Transport
Roads & Maritime
Services

20 September 2012

MP11_0087 – PROPOSED MODIFICATION OF STAGE 1 & 1A, WAGGA WAGGA BASE HOSPITAL DEVELOPMENT, EDWARD STREET, WAGGA WAGGA.

scale at A1 1:750	drawn by FX	checked IH	date JULY 12
project no. 4469	drawing no. CV.MH.000.10	rev. 01

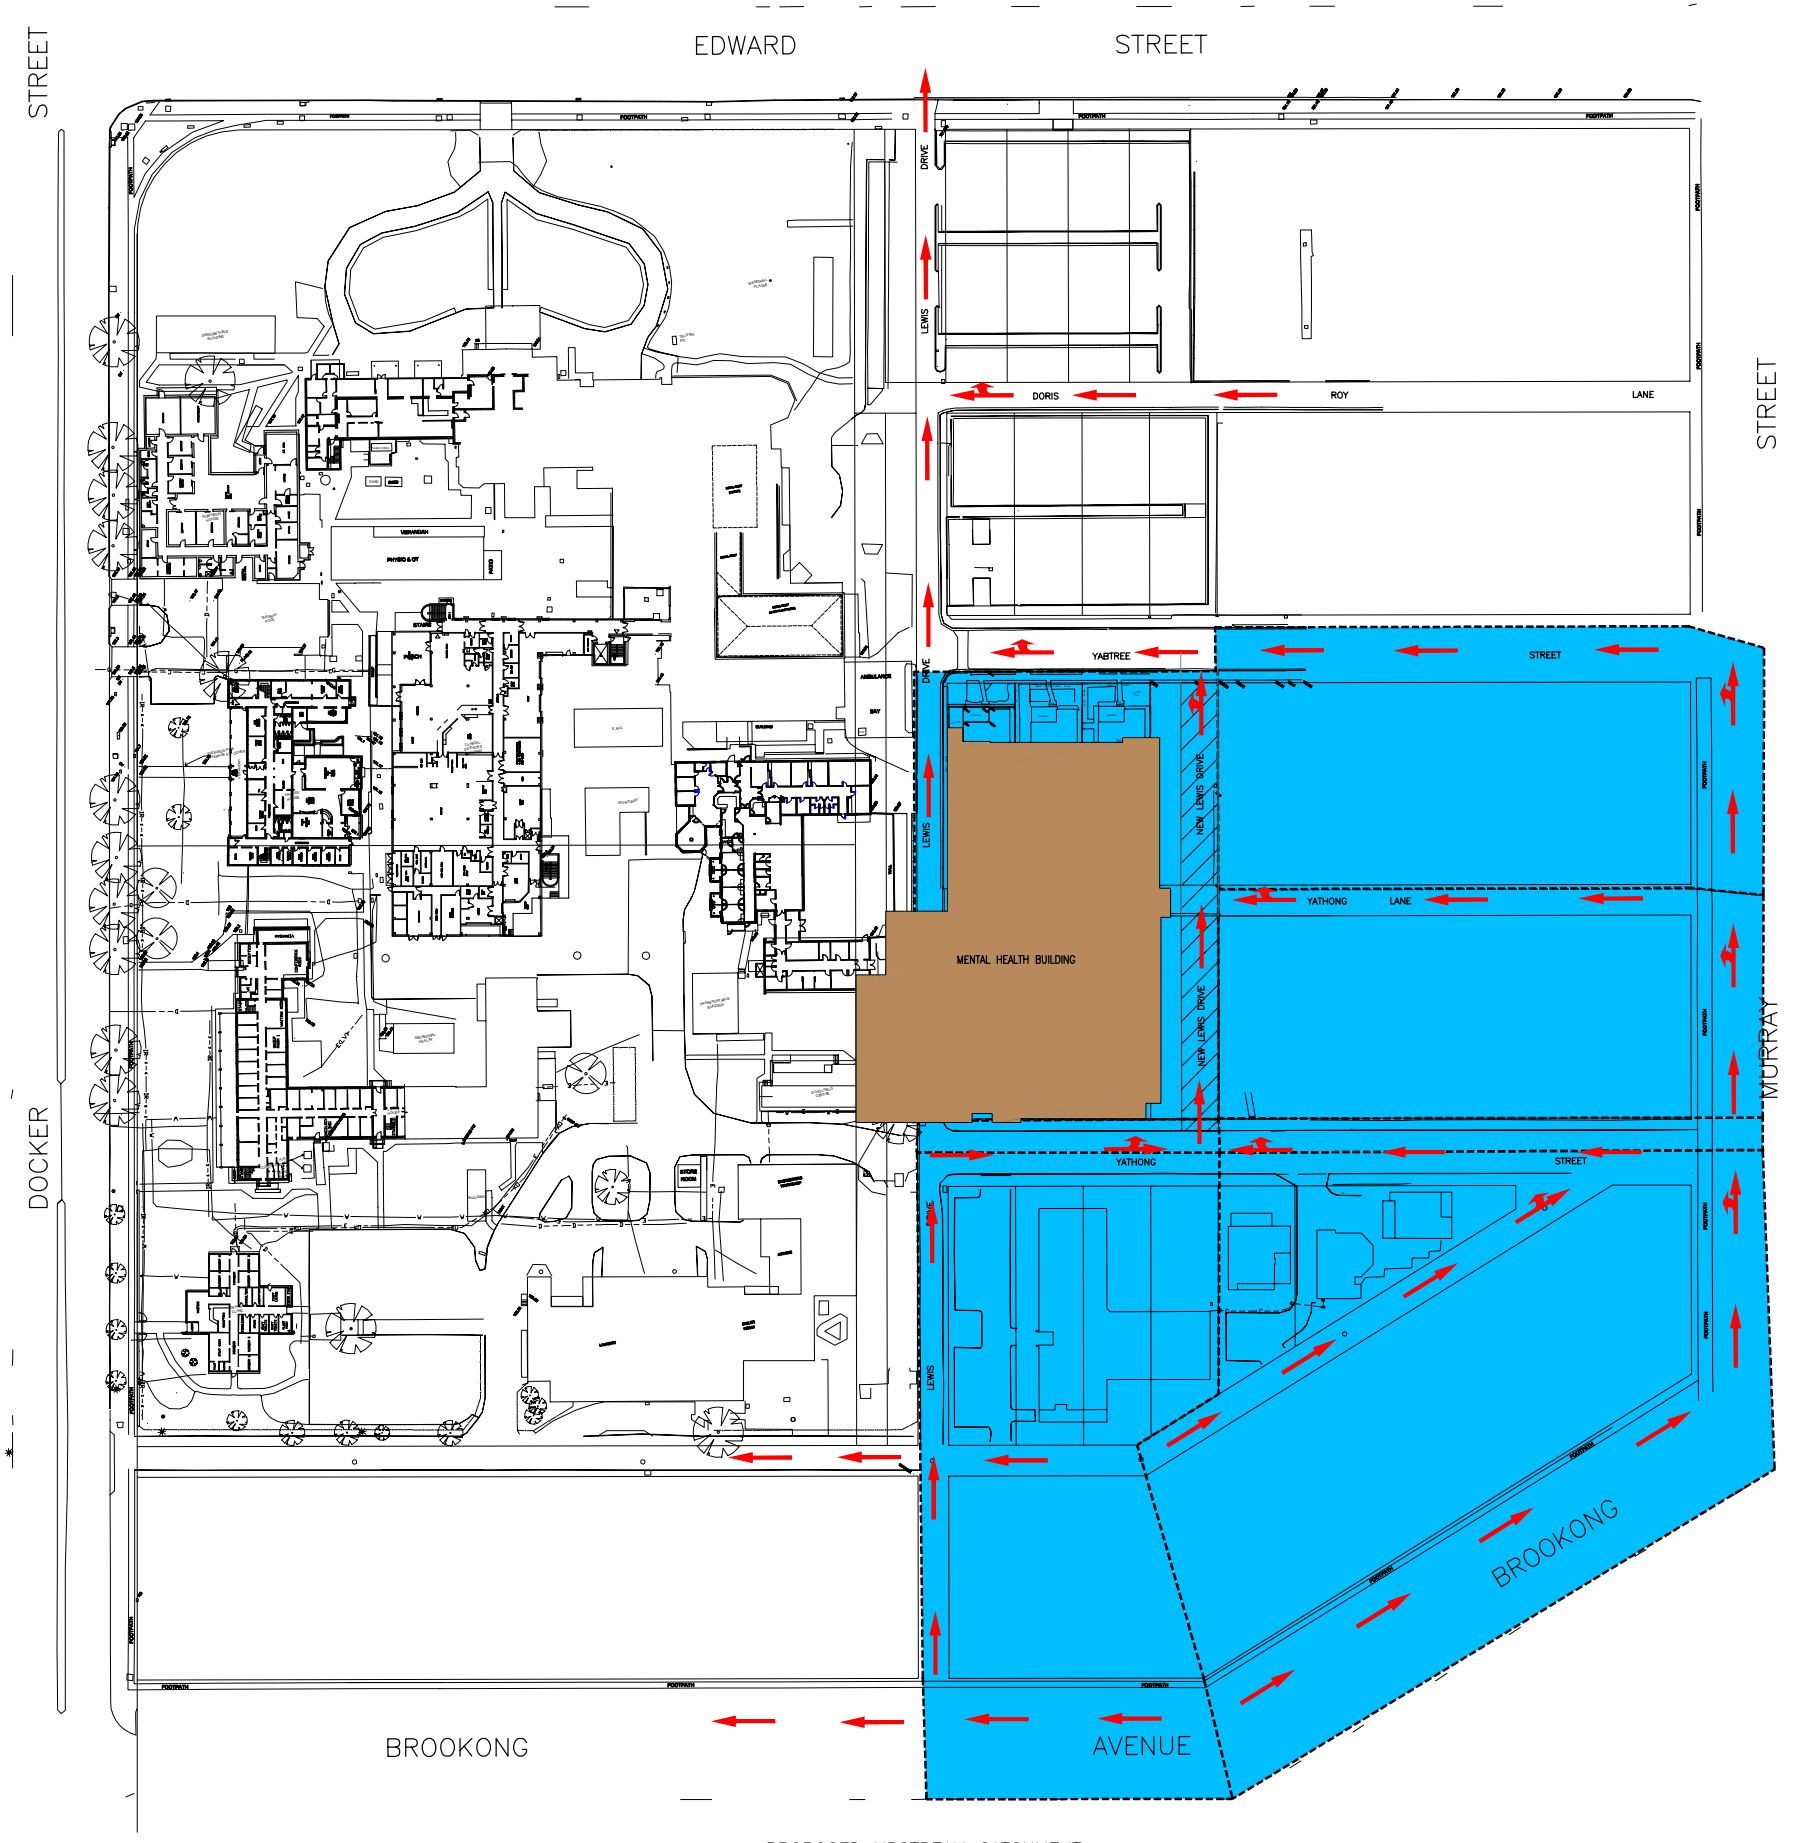
In regards to the proposed changes to the stormwater management system it is noted that whilst the revised design will direct flow along Lewis Drive towards Edwards Street that the overland flow discharge onto Edward Street at its intersection with Lewis Drive will decrease. Notwithstanding this the designed capacity of the overland flow path should not hinder the flow of vehicular traffic into the hospital campus, particularly from Edward Street or alter the discharge point and potentially create additional ponding of stormwater within Edward Street. It is understood from the supporting material that the revised design benefits the potential for future development of the hospital campus whilst not increasing any off site impacts.

Roads and Maritime Services has assessed the modified proposal based on the documentation provided and would raise no objection subject to the Consent Authority ensuring that the development is undertaken and maintained in accordance with the information submitted.
